renewable power ventures

26th May 2006

Reference: A. Dept of Planning Letter of 9 May 06, request for Submissions Report re Proposed Capital Wind Farm (PA No. 05_0179).

Vipac Responses to DEC Questions (Ref S04/01018/1, dated 28/4/06):

FIGURE 10.1
LOCATION OF RESIDENCES AND
BACKGROUND NOISE MONITORING SITES

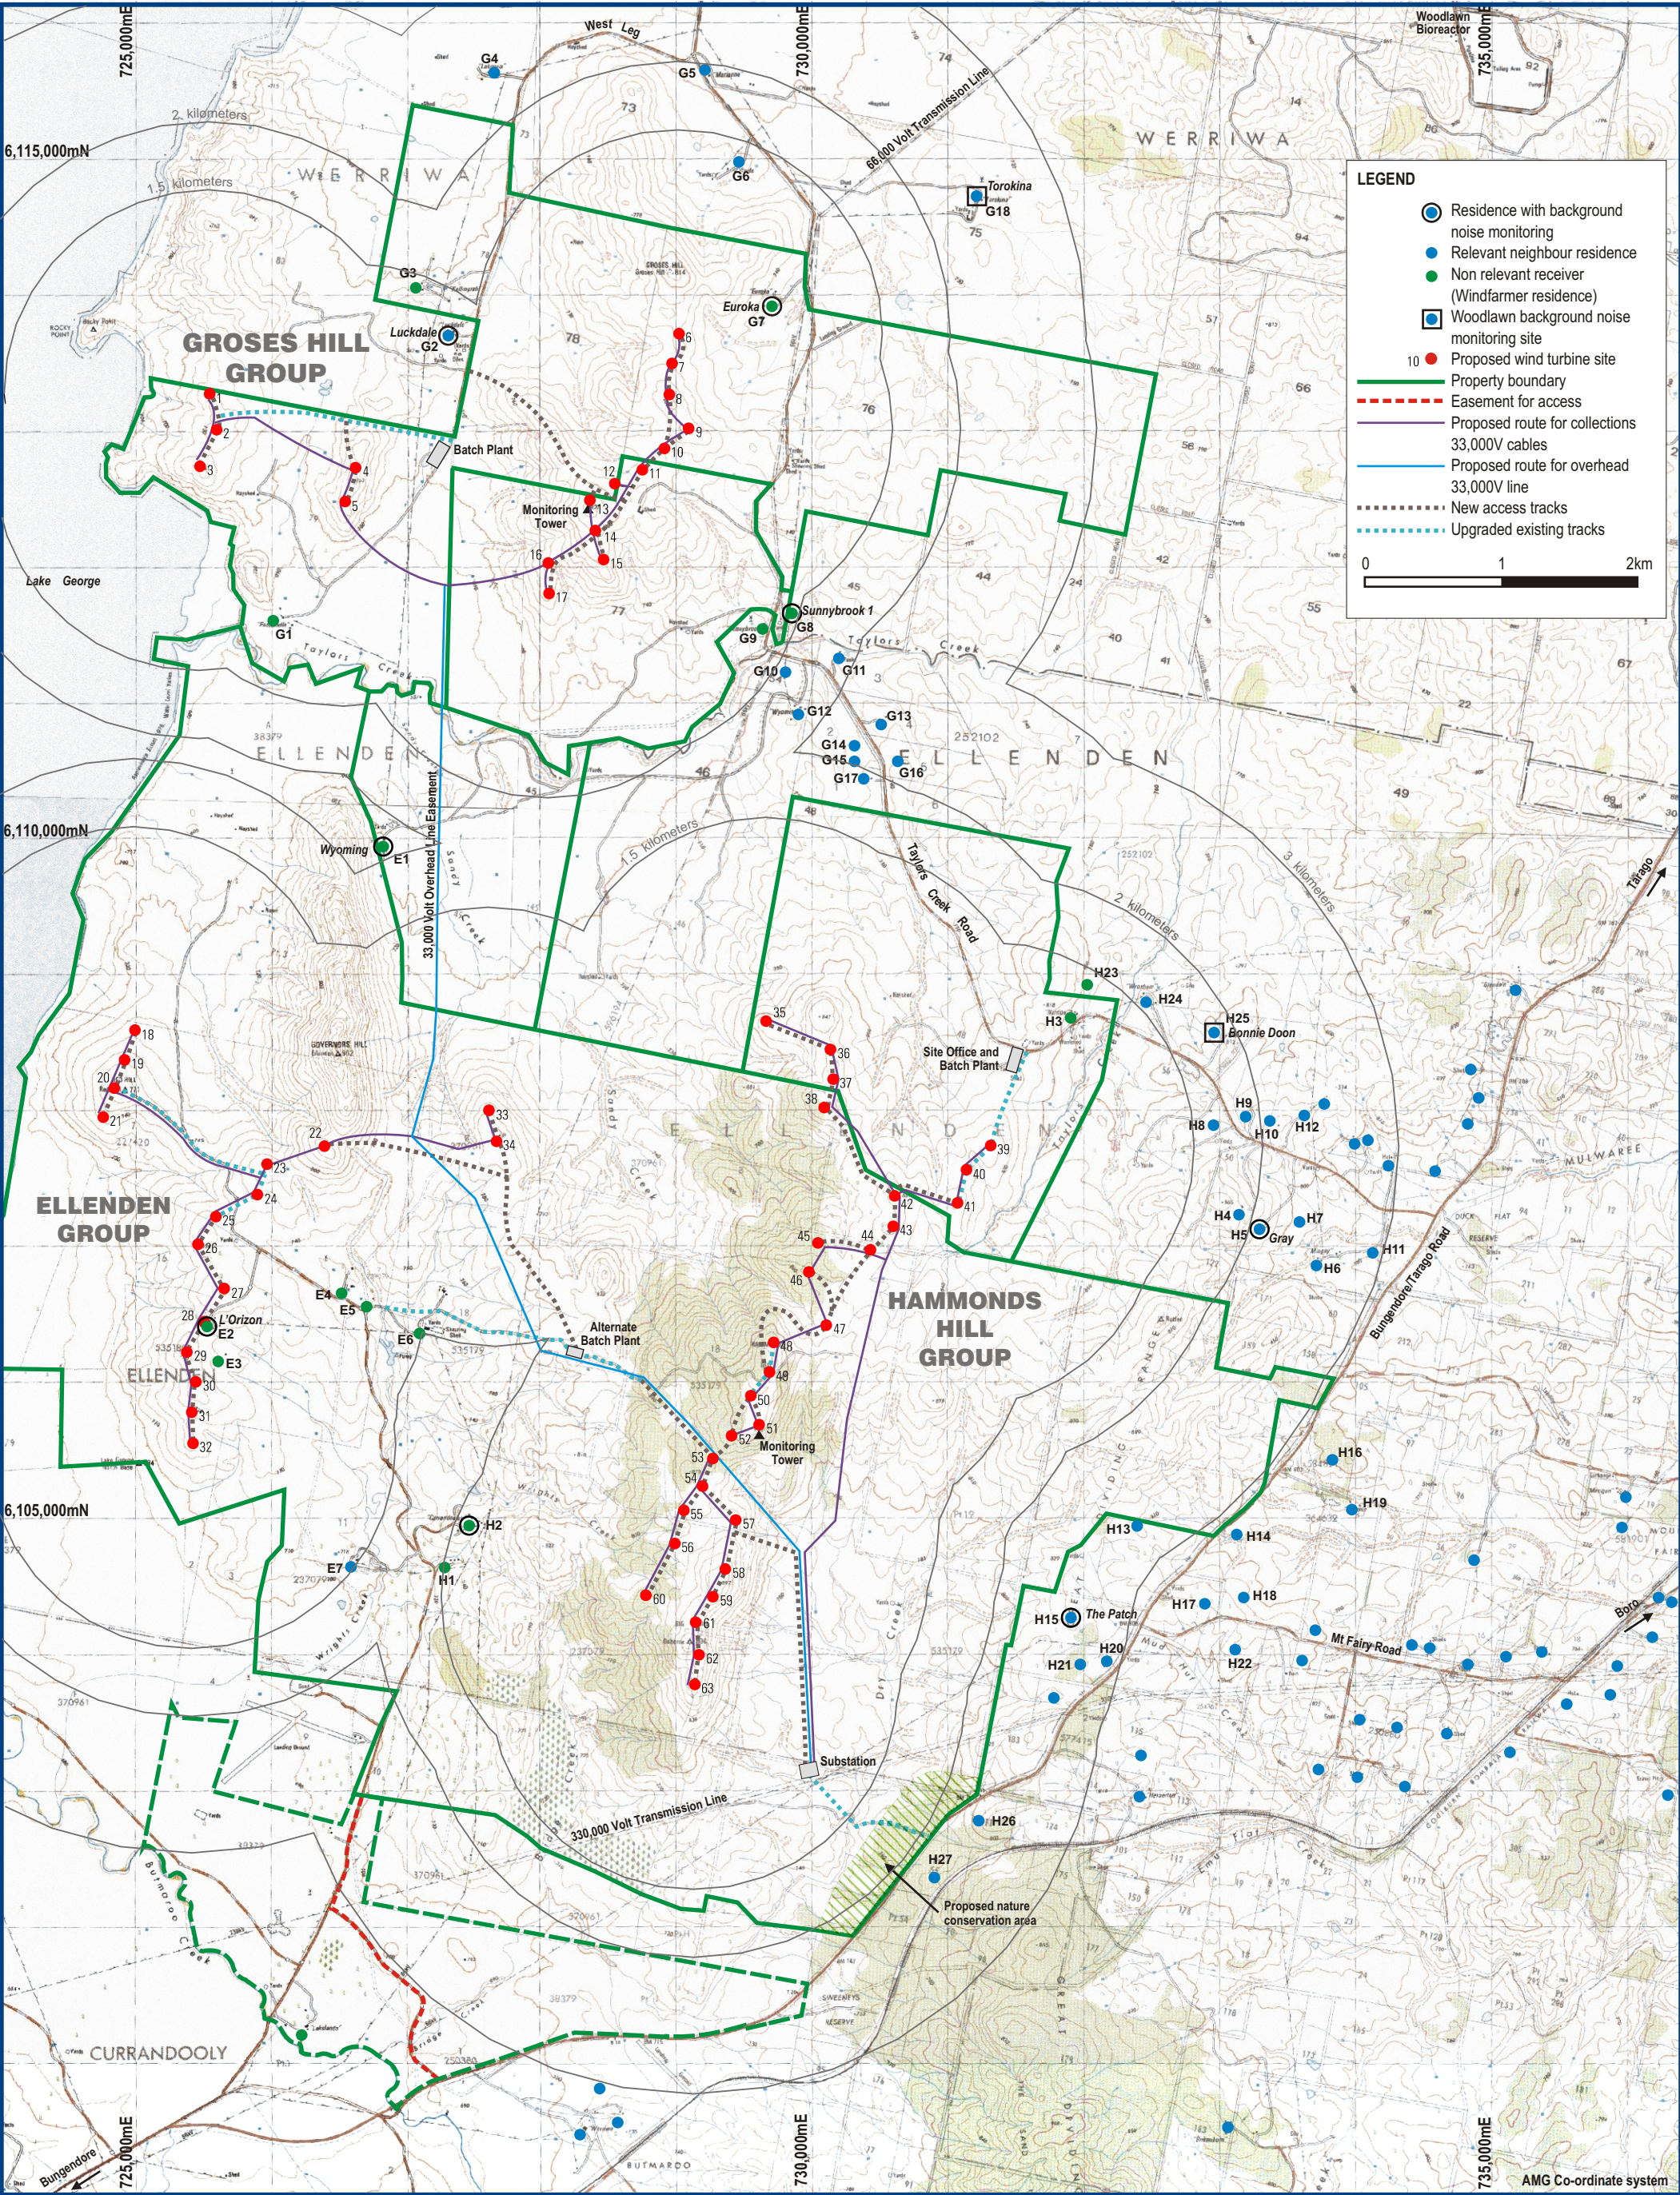
3. The noise prediction modelling has not considered the worst-case wind direction for all receivers;

VIPAC: The modelling was run for the complete range of wind directions and the worst case wind direction was run for each receiver (in accordance with the SA Guidelines). The WNW wind direction is the worst case for most of the receivers. For a few of the receivers other directions were the worst case but in these cases the levels were still very close to the WNW case levels (which were tabulated). We added a clarifying note to section 6 of the final report and note the wind sector management for the 'bad to worst' case directions as part of mitigation options in section 7.2 of report.
